CONSULTEE RESPONSE (Council's Arboriculturist)

Case Officer: Rhiannon Lloyd
Reference: AW/40/26/T
Location: 45 The Drive, Aldwick, PO21 4DS
Proposal: Fell 1no. yew dome (T3) and *Leylandii* hedge (G1).
Reason: Garden re-design (T3)

45 THE DRIVE PO2141DS

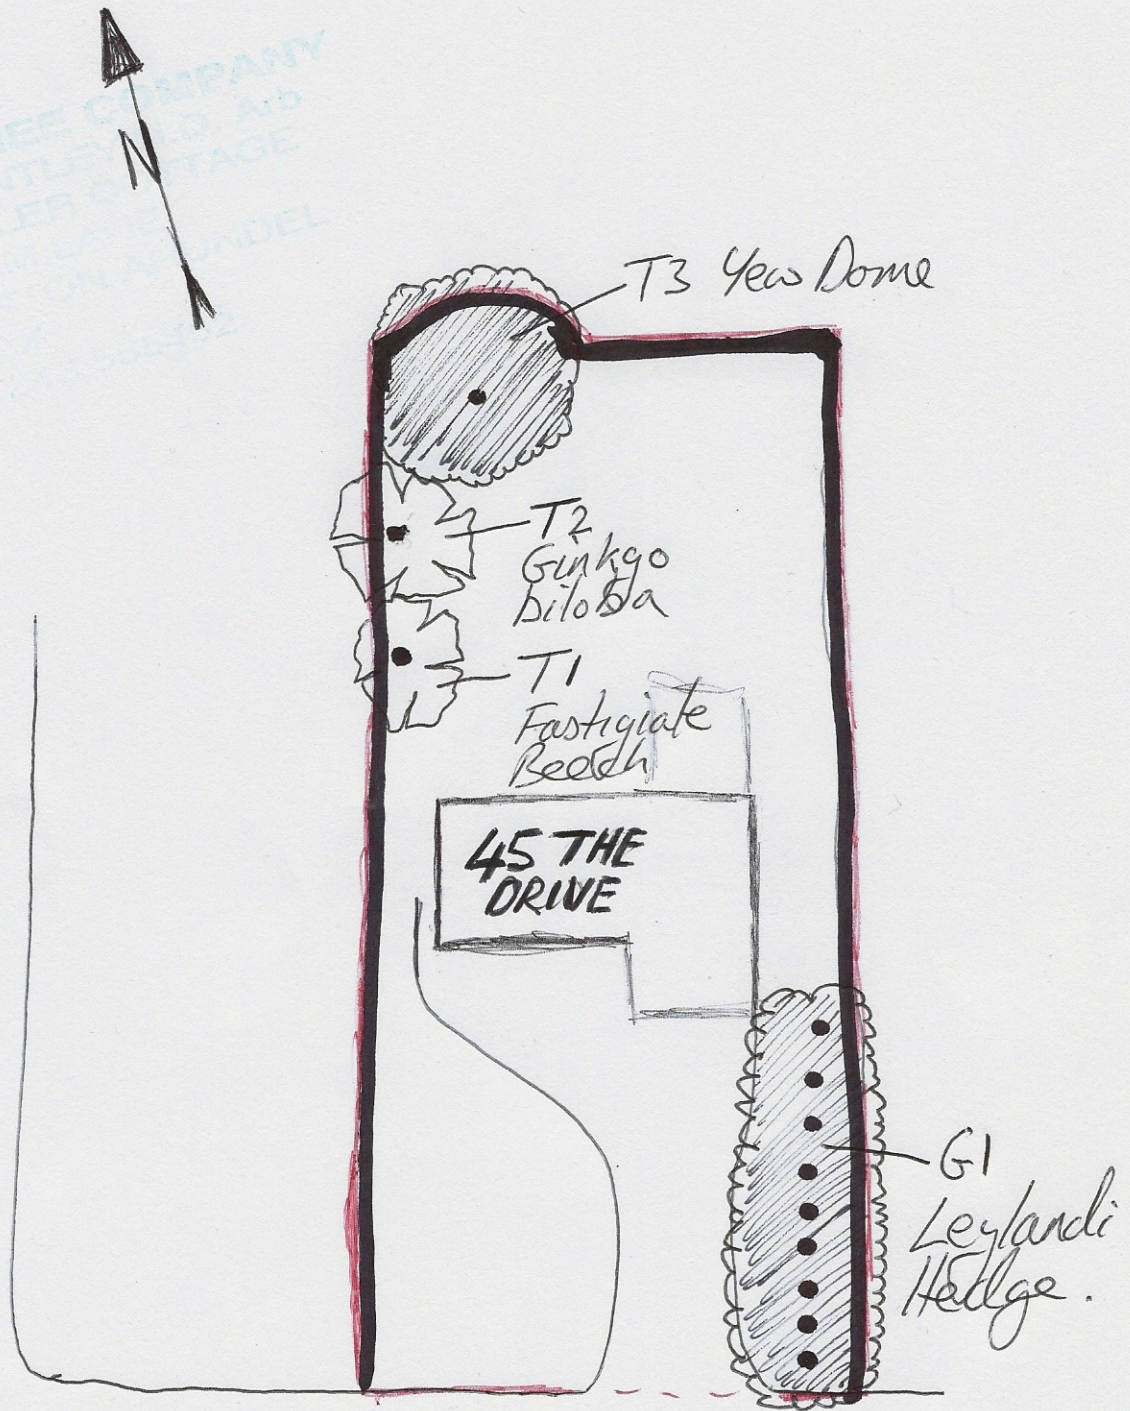
The yew is believed to be a surviving member of the 'yew tree walk,' a historic feature of the original Craigweil House and its environs, with other examples found in neighbouring property.

It is visible only in small part from the estate road (Queensway) and adjacent properties, having been regularly trimmed to produce a compact form. Its landscape impact has been diminished by subsequent development of its surroundings.

The applicant/agent provide no arboricultural justification for its removal.

Whilst the tree does not provide much visual amenity, it seemingly remains in a sound and healthy condition, with usual life expectancy for its type. The tree is of local historic interest and contributes to the character and appearance of the area. Its removal has not been justified on arboricultural grounds.

We refuse consent for this application.
